## **Appendix 1.1 – Section 5 of the officers Delegated Report – Consultation**

### HEATHROW AERODROME SAFEGUARDING:

TREES/LANDSCAPE OFFICER:

Title: 210 PROPOSED H3G SITE PLAN

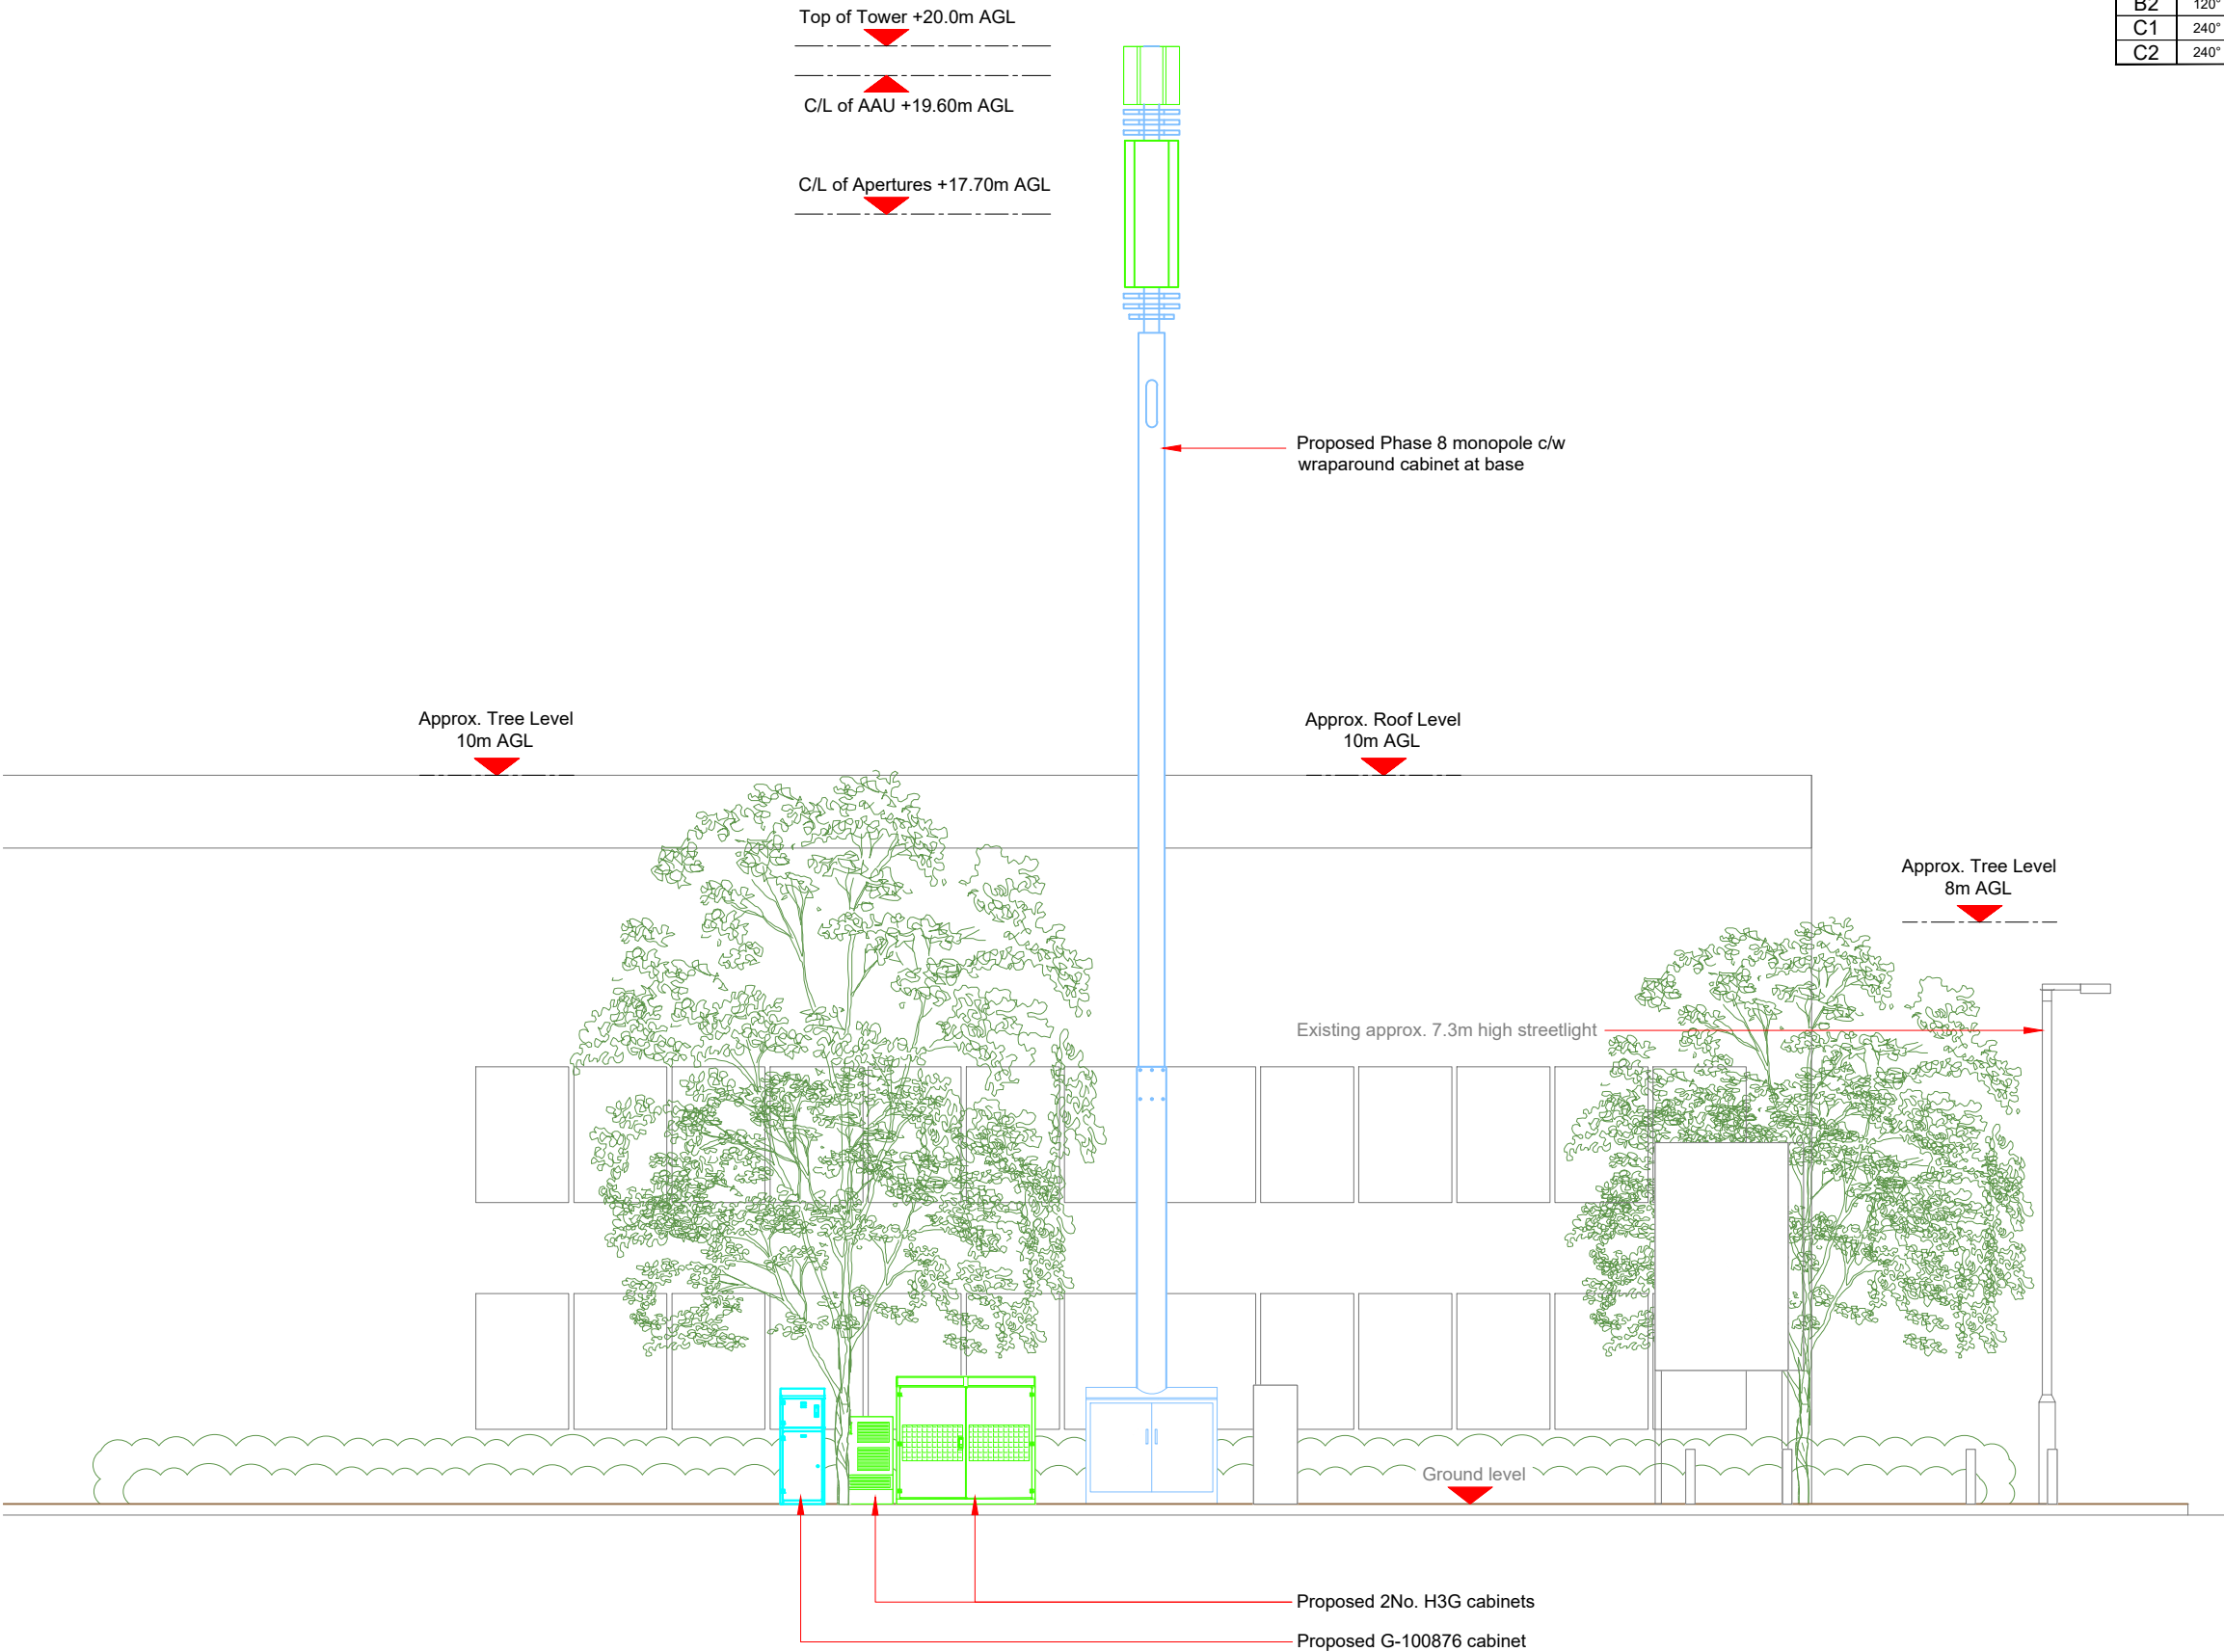
COMMENT - The proposed location of the mast is closer to the tree than is ideal. It is likely to encroach into the RPA (root protection area) of the lime tree. Furthermore the crown of the tree is relatively low and full on the west side - closest to the mast. It is likely to snag the mast either during installation or at a later date. The proposed mast will be close to the free-standing cabinet and additional free-standing cabinets will be lined along the back edge of the footway to the west (towards the junction with Silverdale Road. This location has no sensitive receptors, being primarily industrial / commercial in character, with no adjacent residents. The footway width is sufficient to accommodate the telecom equipment without compromising pedestrian movement or safety.

RECOMMENDATION -The proximity of the mast to this healthy looking street tree (in an area which is relatively devoid of trees) renders this application unacceptable. - If the mast could be re-positioned to the west of the existing cabinet (closer to the junction with Silverdale Road) the objection would be removed.

COMMENT: The report by TEP confirms that in order to safeguard the street tree (a 'B' grade lime), the installations will need to be hand dug, under arboricultural supervision. Until the excavation takes place, the full impact of the proposal on the existing root structure cannot be known. It will also require tree some cutting back of the lime tree on one side to accommodate the installation,

The plan indicates that this will unbalance the crown of the tree and spoil its form. Furthermore, there is every likelihood that the tree will require regular pruning in the future order to control its re-growth towards the mast. The combination of these constraints indicates that the juxtaposition of the mast with the existing street tree is unsustainable with several details which could adversely affect the tree in the medium to long term.

RECOMMENDATION: While there is an acknowledged need for the telecoms installation, this area is dominated by industrial estates and there must be other locations nearby which will not jeopardize the future of an attractive 'B' grade street tree, a public asset. The application fails to safeguard the long-term future of a tree of merit in the public realm and therefore fails to satisfy policies DMHB12, DMHB14 and DMHB21. It should be refused.
